HARNETT COUNTY

DEPARTMENT OF PUBLIC HEALTH

Edward Swann **RE: County of Harnett Land Use Application #01-5-**
P O Box 5305
Sanford, NC 27330

RE: Land Use Application HTE#01-5-3471

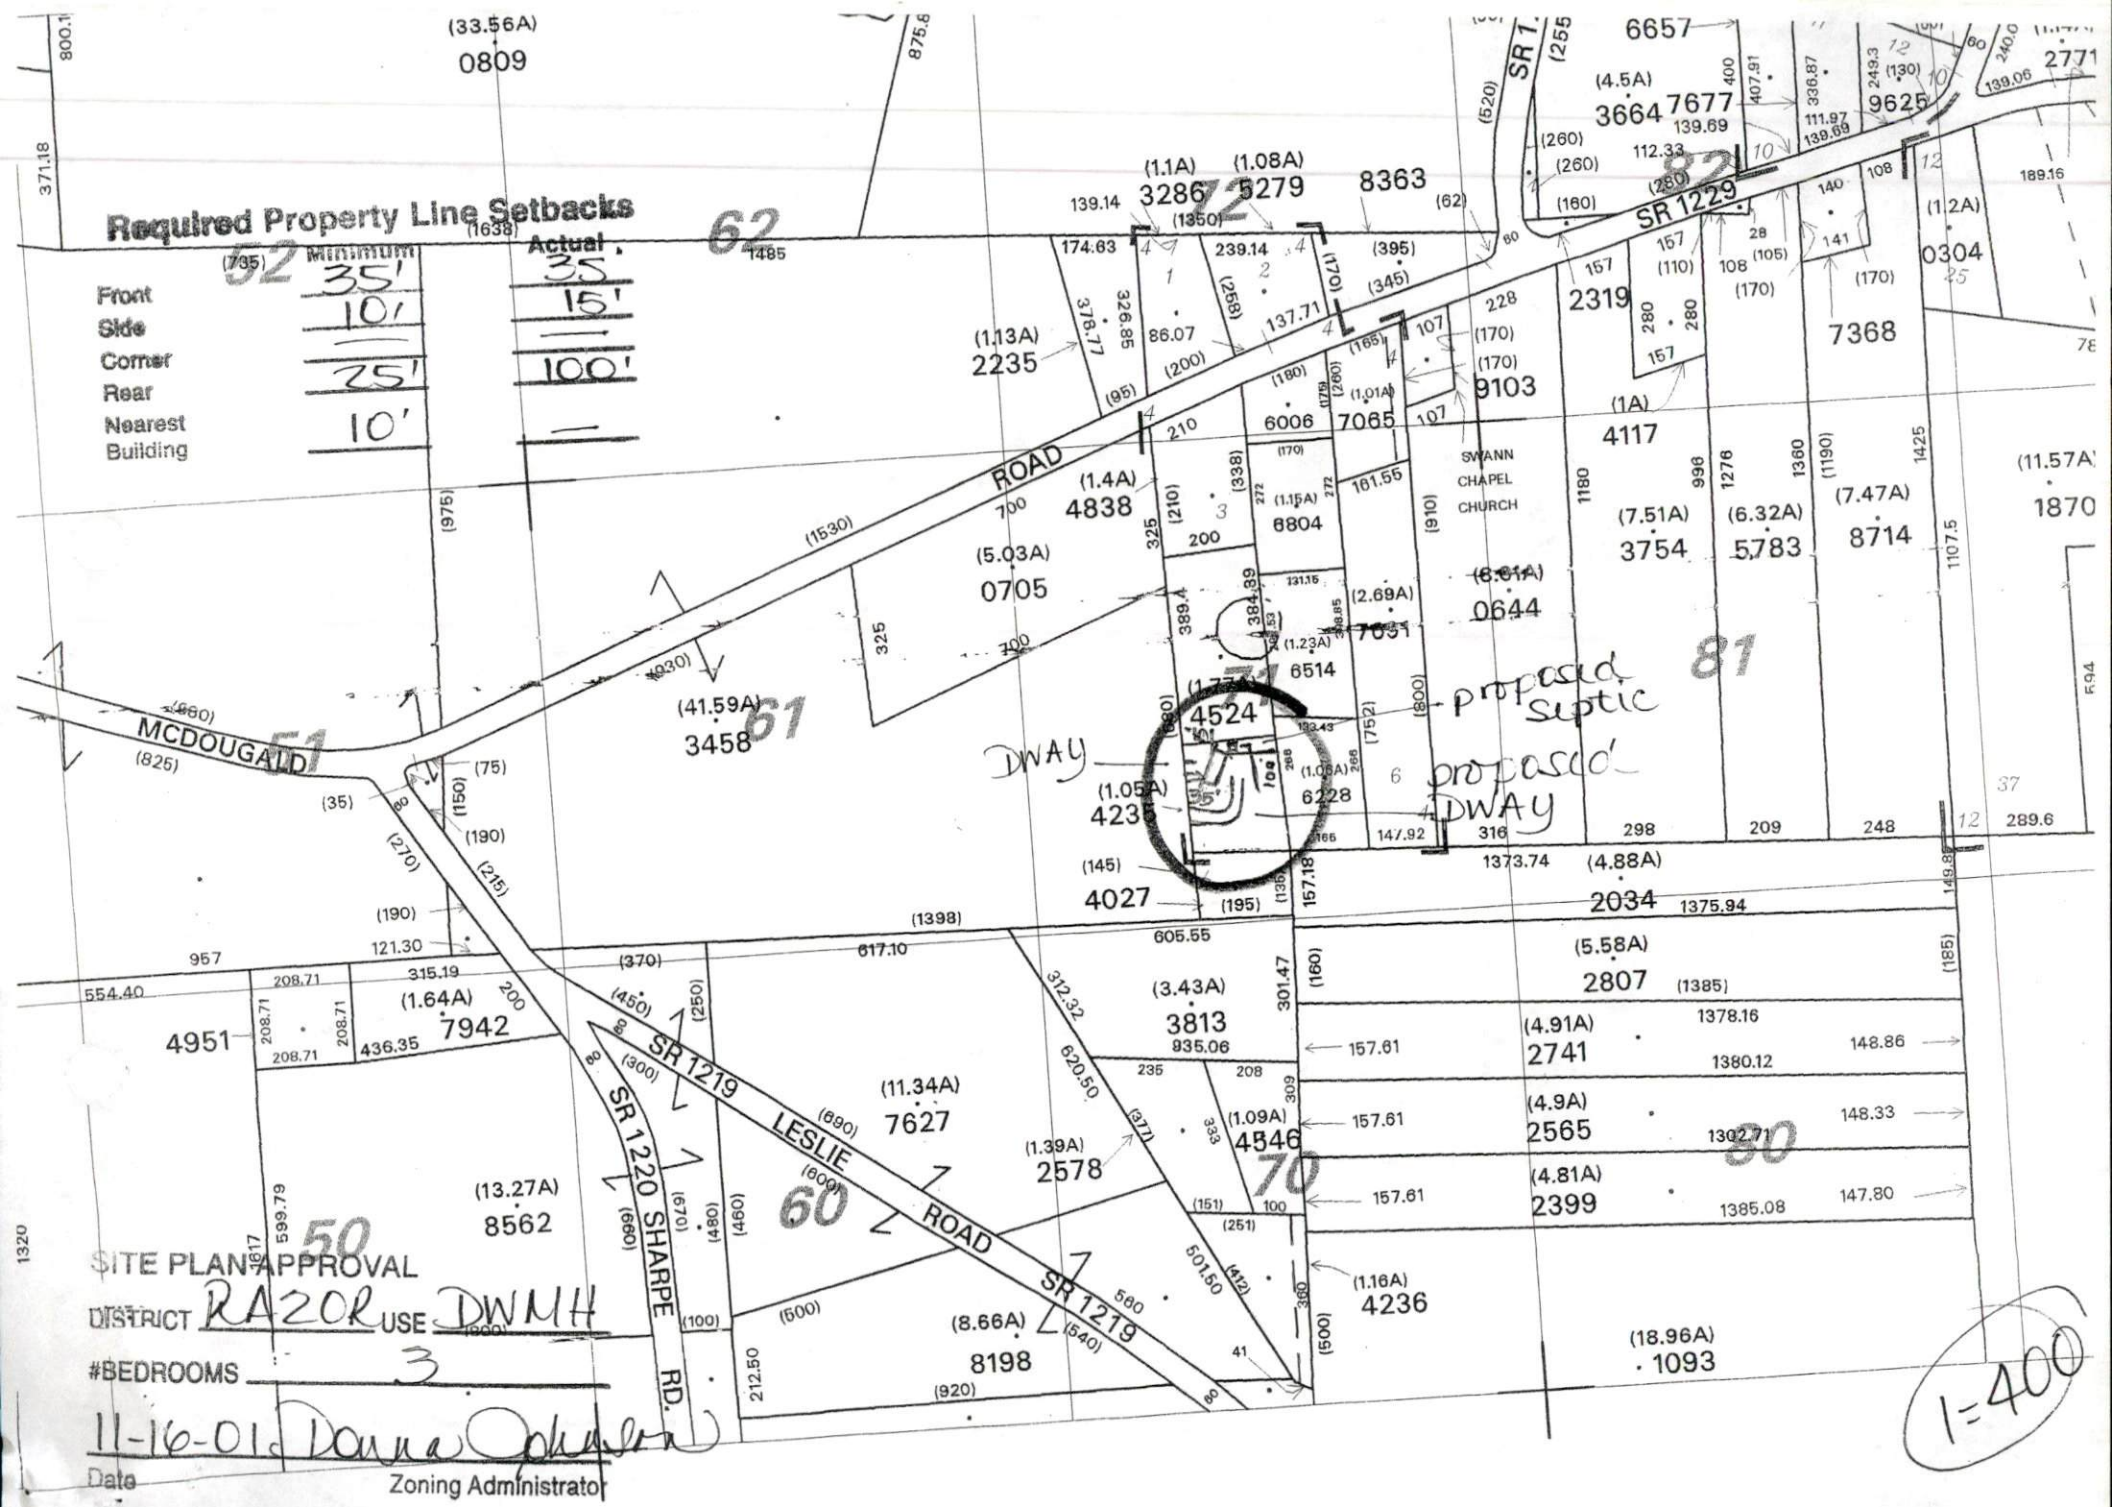
According to the map submitted by you, the house site is located on a tract of land located approximately 600 feet from SR 1229. You have the house site staked approximately 250 feet from SR 1229. I need to know which is correct. You will need to do either of the following:

- A- Submit a correct plot plan matching your homesite,
- B- Move homesite to match plot plan,

You will also be required to submit a survey map of the correct tract of land.
